**RE: 815 Roger Griffiths Avenue
Urban Design Brief**

In support of the Site Plan Control Application for the lands at 815 Roger Griffiths Avenue in the City of Ottawa, please find our Urban Design Brief enclosed. Per the Urban Design Brief Terms of Reference received from City staff following the pre-consultation meeting taking place May 6, 2025, alternative site plan options and responses to the urban design direction provided are included below.

1.0 Response to Urban Design Directions

The following comments were received from staff as part of pre-consultation feedback dated June 2, 2025.

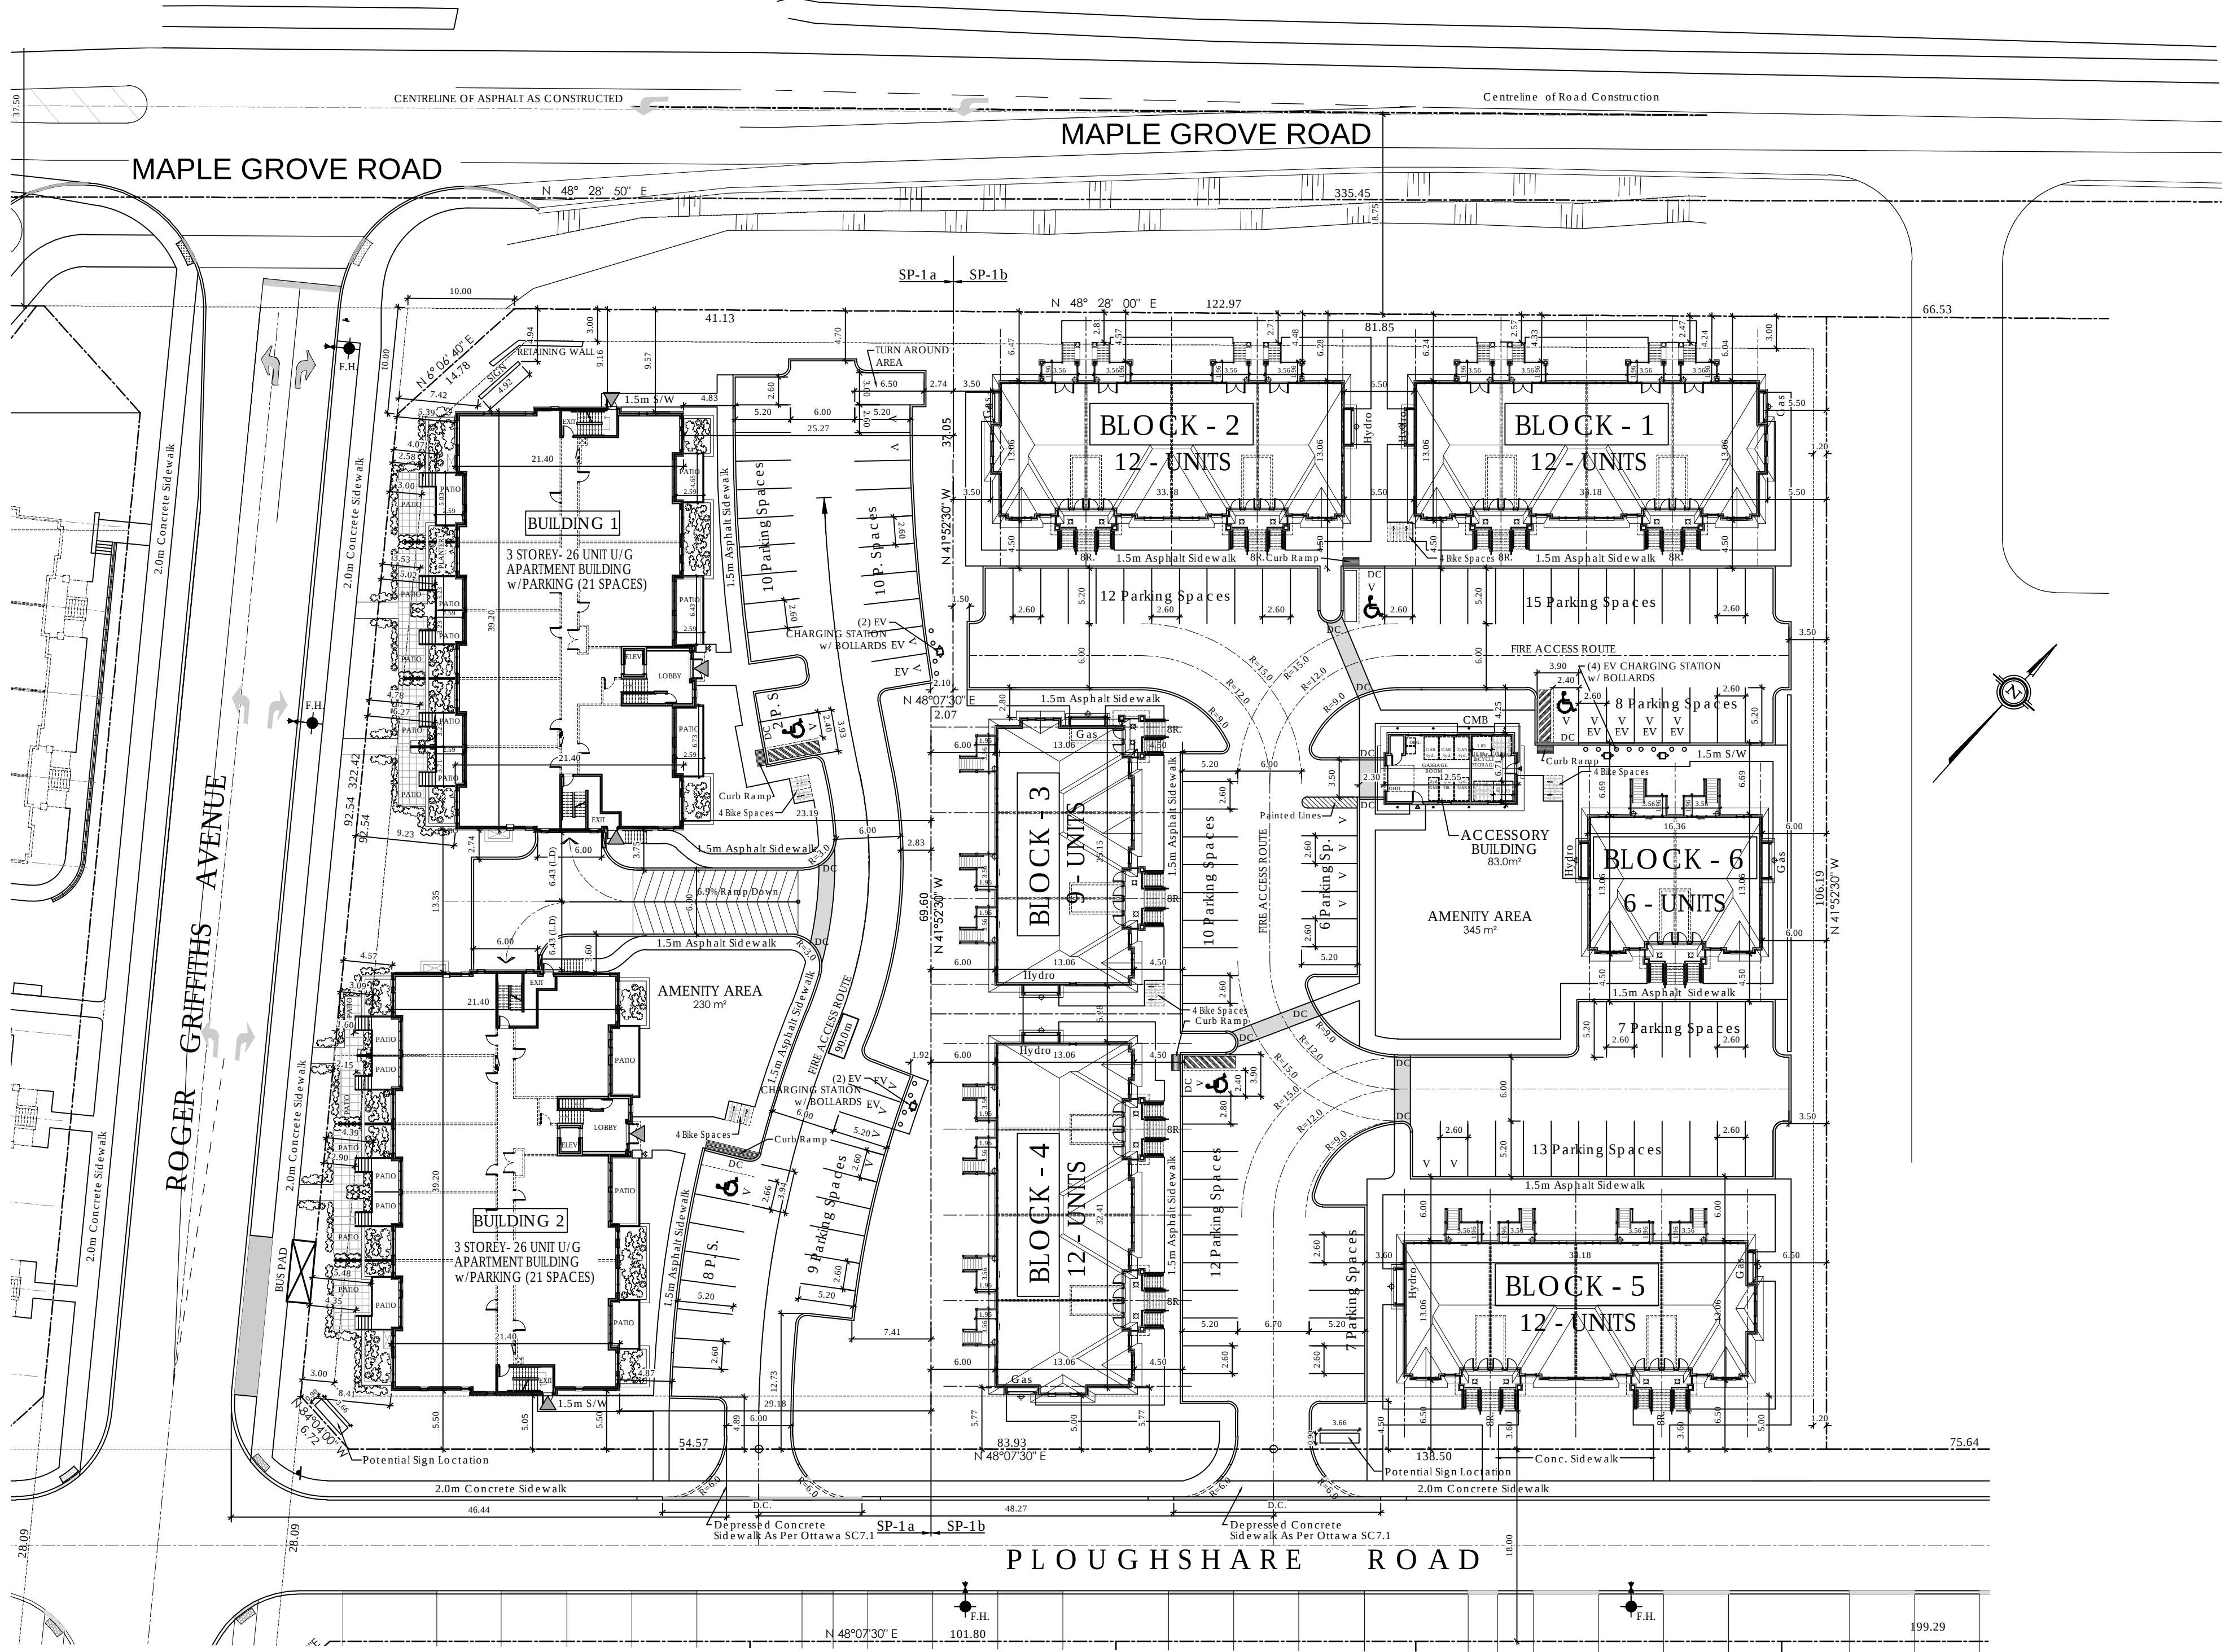
1.1 I recommend orienting the two low-rise buildings to be parallel with the street they face.

1.2 I recommend designing the entrances fronting the public right of way read as main entrances and not rear exits to support the streetscape and connect with the surrounding community.

The orientation of the apartment buildings is limited by the design dynamics of the underground parking access. The proposed orientation also allows for the opportunity to provide larger planters which improve the streetscape.

Per the submitted building elevations, entrances of the ground floor units facing Roger Griffiths Avenue connect to the streetscape and provide tenant access. Nonetheless, due to the accessible design of the apartment buildings, internal access is expected to be used more frequently.

The street elevation has an active façade with balconies and terraces providing eyes on the street. Five units in each building at the first floor have private terraces with stair connections to lower patios and private gardens, providing a vivid interface with the public realm.
